Sent: 16 September 2013 18:46
To: Planning
Subject: Welwyn Hatfield Council Online Planning - Comment

Application Number: S6/2013/1884/LUP

Name: Mr and Mrs MOY

PROPOSED REAR ELEVATION

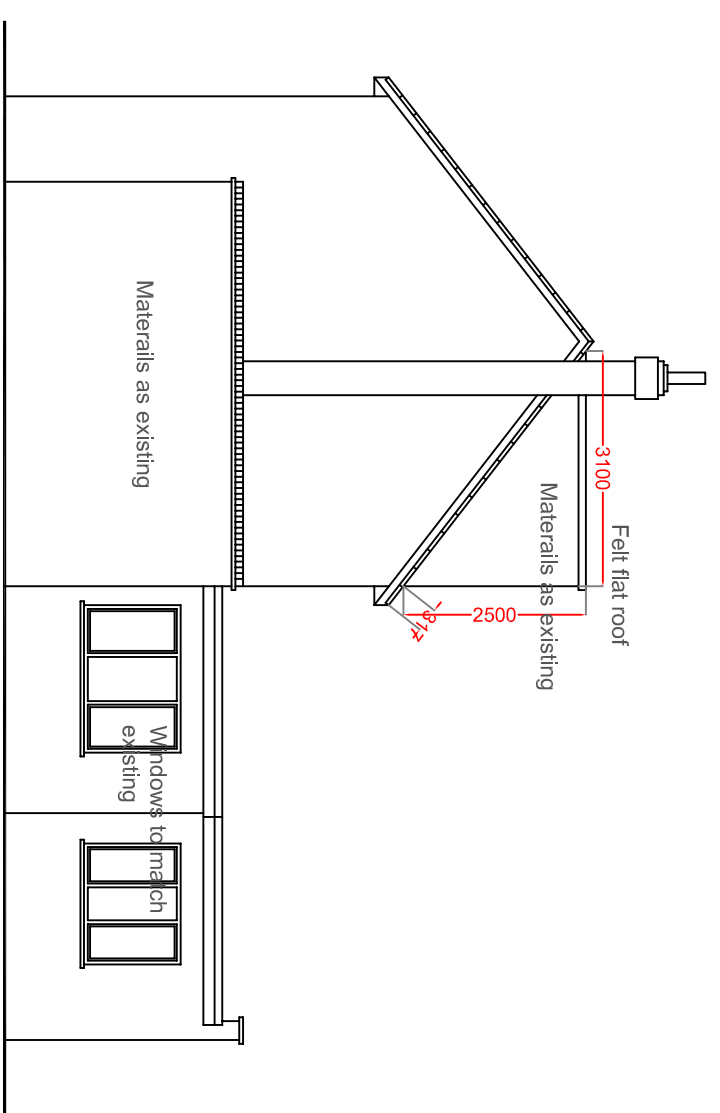
Comment: The proposed development of the loft windows and 1st floor windows will have a negative impact on our amenity and result in a loss of privacy and be overbearing on a day to day basis. The rear 1st level and loft windows will look directly into our living room making it feel like we are in a goldfish bowl. We strongly object to the development.
